**From:** Josh Pozzobon <josh@builtprefab.com>  
**Sent:** Tuesday, October 7, 2025 8:56 AM  
**To:** Geoffrey Gray  
**Cc:** Ellie Myers; Ian Garrity; Jamey Ayling  
**Subject:** Re: CARA Referral  
**Attachments:** 1578002 SITE PLAN R1.pdf

**Subject:** RE: CARA Referral

SITE PLAN

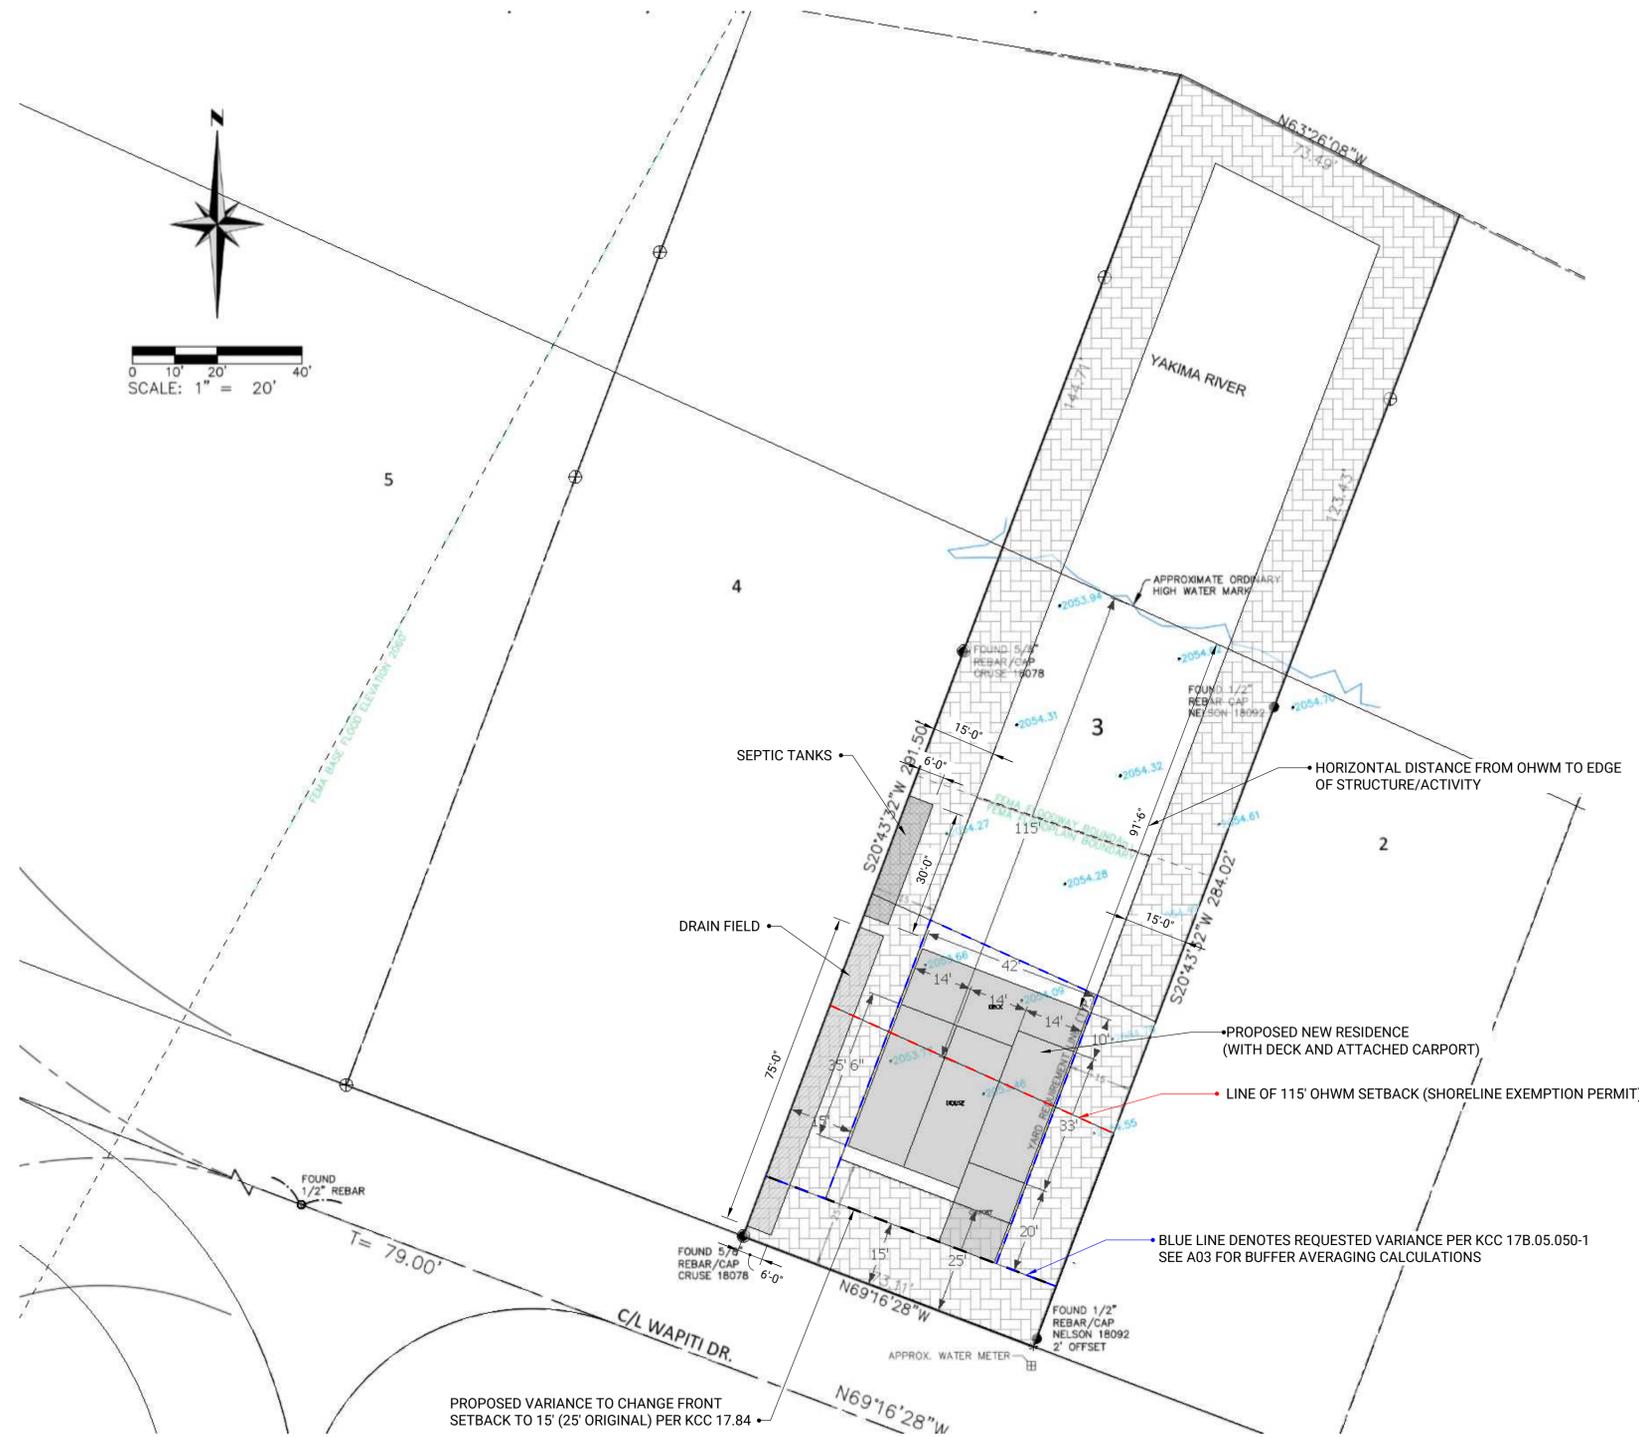
When you say "we are comfortable proceeding with the idea of establishing a 115-foot buffer and setback on the eastern property line", does that mean having the whole eastern property line as a non buildable area (shoreline buffer) like we had shown on our most recent site plan? Or are you meaning something different.

The Common Line Shoreline Buffer, outlined in KCC 17B.06.200(B)(7), allows an applicant to place a residence on a vacant lot if single-family homes exist on both adjacent lots, which we previously stated couldn't be used because the eastern lot is vacant. However, we are comfortable proceeding with the idea of establishing a 115-foot buffer and setback on the eastern property line. This would represent the maximum distance at which a house could be placed on this lot.

To move forward, you will need to determine the exact distance from the Ordinary High Water Mark (OHWM) to the cabin located at 1181 Wapiti Dr. Although satellite imagery suggests the cabin is approximately 65 feet from the river, a more accurate, on-the-ground measurement will be required. Please do not access private property without permission.

Once you have that measurement, you will calculate the average of that distance and 100 feet. Then, you'll need to add the standard 15-foot building setback and apply the 25% reduction allowed under KCC 17B.06.200(B)(12), which results in a final setback of 11.25 feet.

With this, I can now confirm our Common Line Shoreline Buffer is 91.3' (91'-3 5/8"). My math is below;

$100' + 60.1' / 2 = 80.05'$  Avg.

$80.05' + 11.25'$  (15' building setback + 25% reduction per KCC 17B.06.200(B)(12)) = **91.3'**

When we refer to "establishing a 115-foot buffer and setback on the eastern property," we are not designating the entire eastern property line of 1151 Wapiti Dr as a non-buildable shoreline buffer.

Instead, we are using the 115-foot measurement from the ordinary high water mark (OHWM) of the *eastern property* to establish a theoretical boundary for the purposes of applying the *common line setback* approach. This line helps define the setback for the proposed development on the subject property.
